Subject: Pemulwuy Mixed Use Development, Redfern (MP06_0101 MOD 1 & MP11_0093)

1. I have reviewed the Pemulwuy Mixed Use Development (MP06_0101 MOD 1 & MP11_0093) and the submitted plans on exhibition at the NSW Department of Planning & Infrastructure, 23 -33 Bridge Street, Sydney.

1 Eveleigh Street Elevation

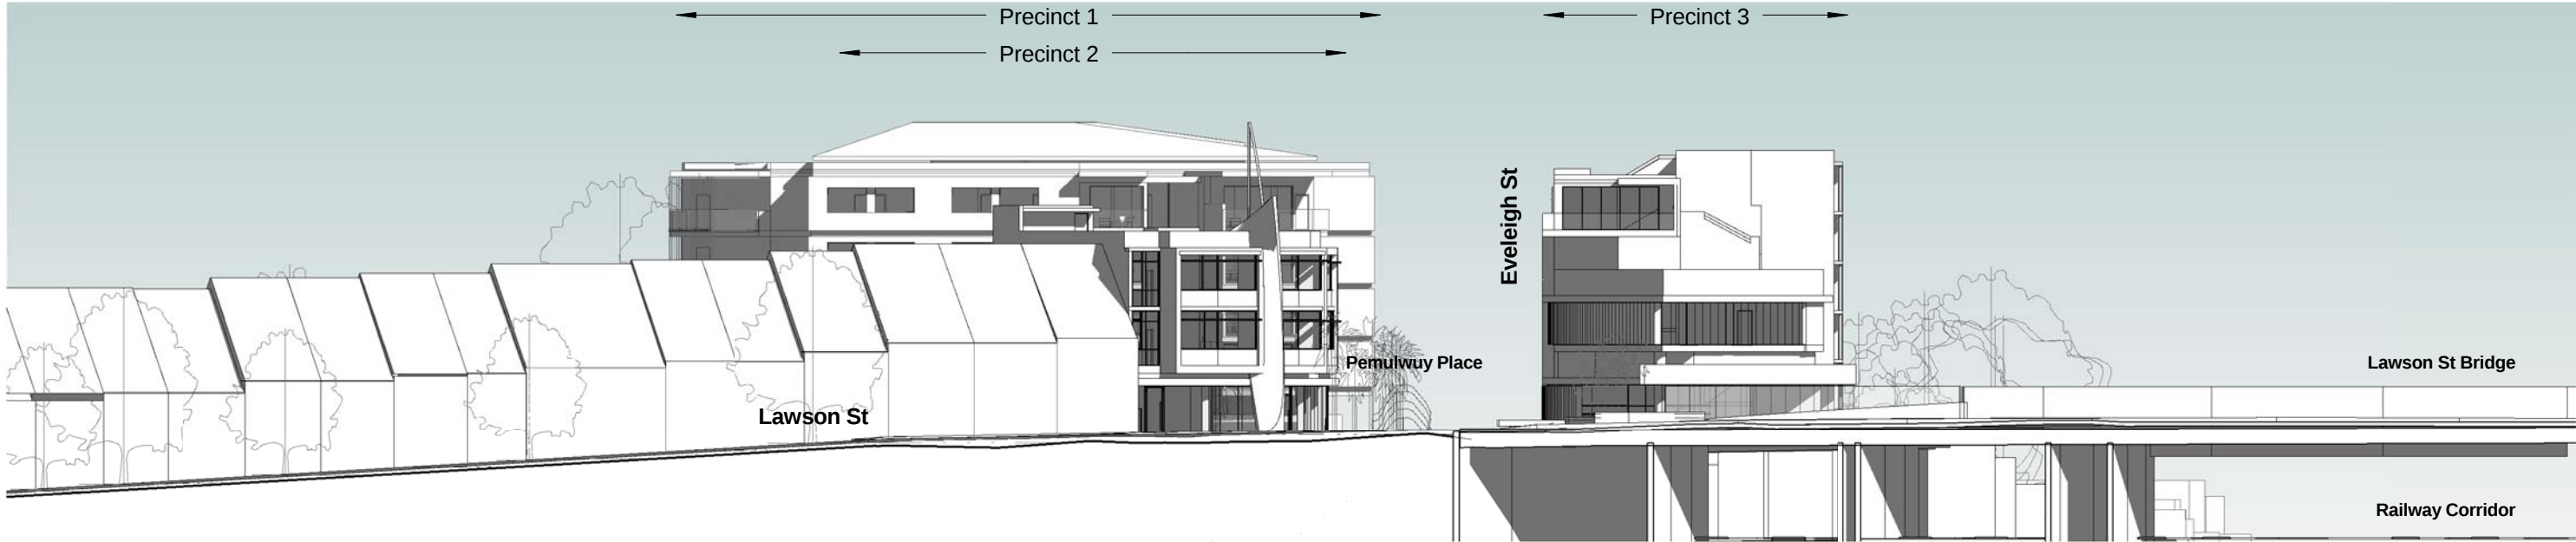
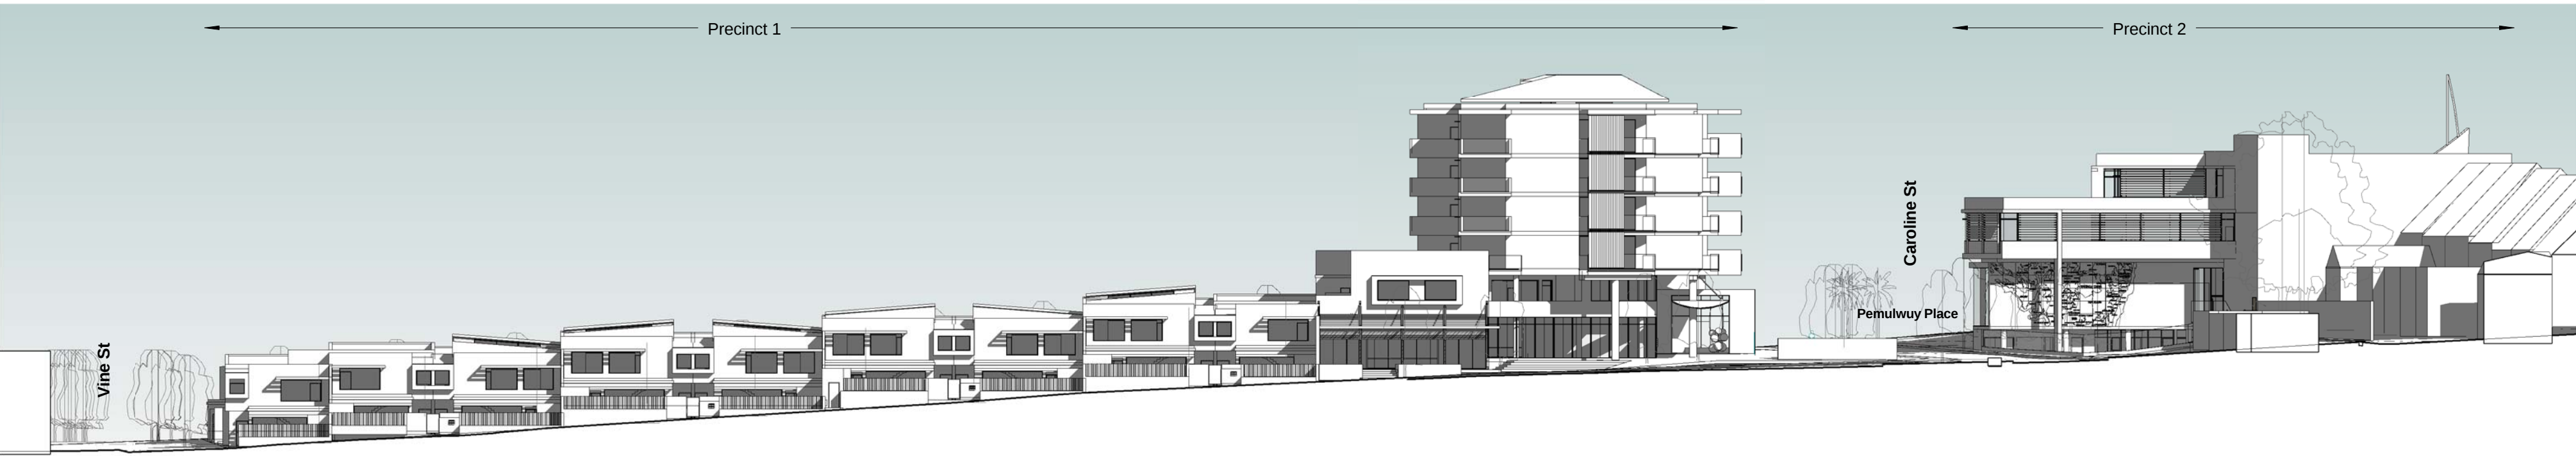
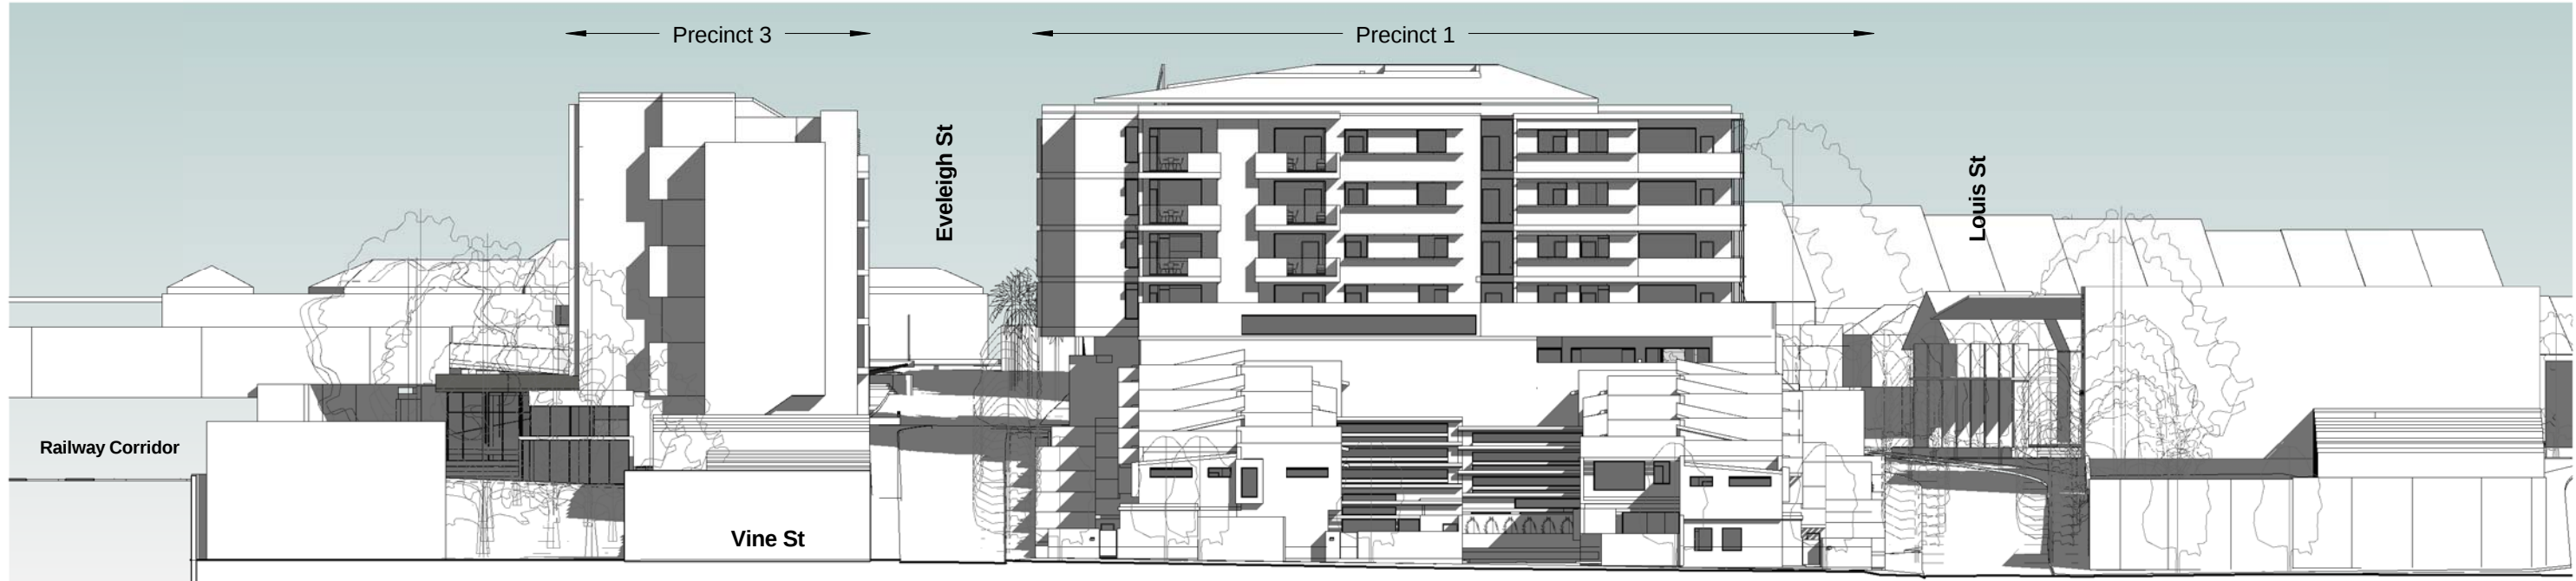
- b. the size and location of the gymnasium – particularly as a gymnasium already exists; and
 - c. the colours and branding proposed detract from the area.

- d. the facades of the buildings within the Development have little merit, in particular the affordable housing and should be re-designed so that they are in keeping with the Redfern area;
